Harnett County Government Complex
307 Cornelius Harnett Boulevard
Lillington, NC 27546

Re: Status of Improvement Permit Application #09-5-23177

An attempt was made to evaluate your property for the purpose of issuing an Improvement Permit. The evaluation could not be completed for one or more of the following reasons.

1" = 60'  
SITE PLAN APPROVAL  
DISTRICT RA 30 USE SFD  
#BEDROOMS 3BD  
11/2/09  
ZONING ADMINISTRATOR  
Joy Wilson Buley  
09-500-23177A

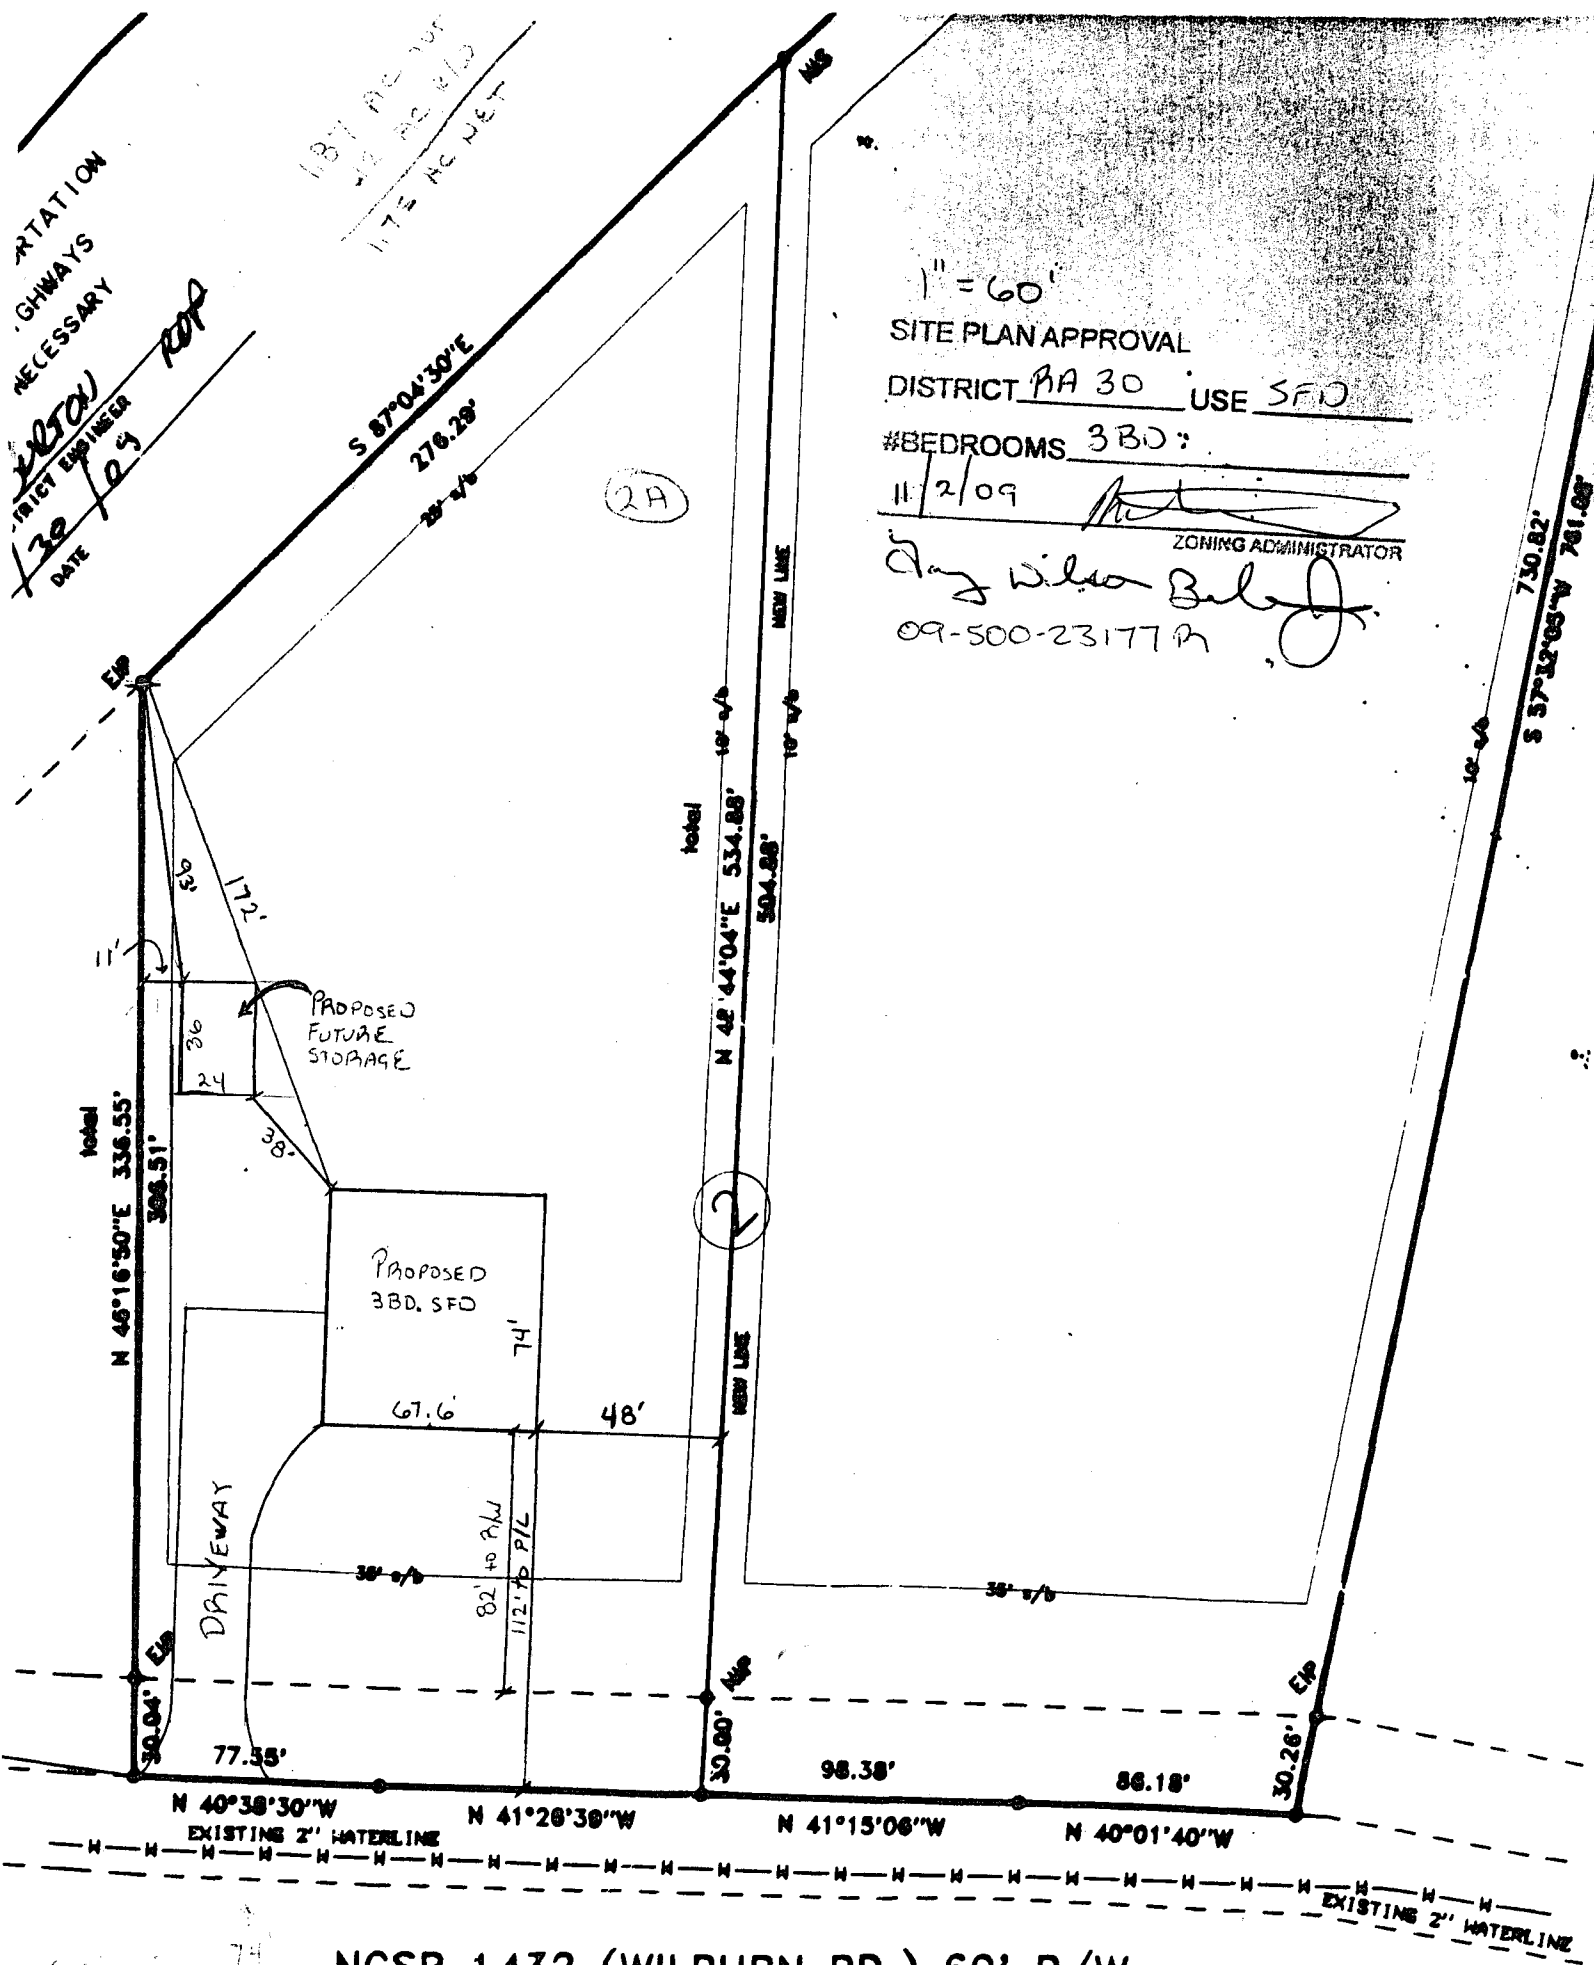
- 1. Use pink flags to mark property lines and irons that are set by surveyor need to be visible *(\$25.00 fee incurred)*
- 2. Use orange flags to mark house corners *(\$25.00 fee incurred)*
- 3. Directions not clear to property *(\$25.00 fee incurred)*
- 4. Property needs only brush or vegetation removed
- 5. Backhoe pits required
- 6. **Other – Setbacks are incorrect and lot needs clearing. Call me if you have questions.**
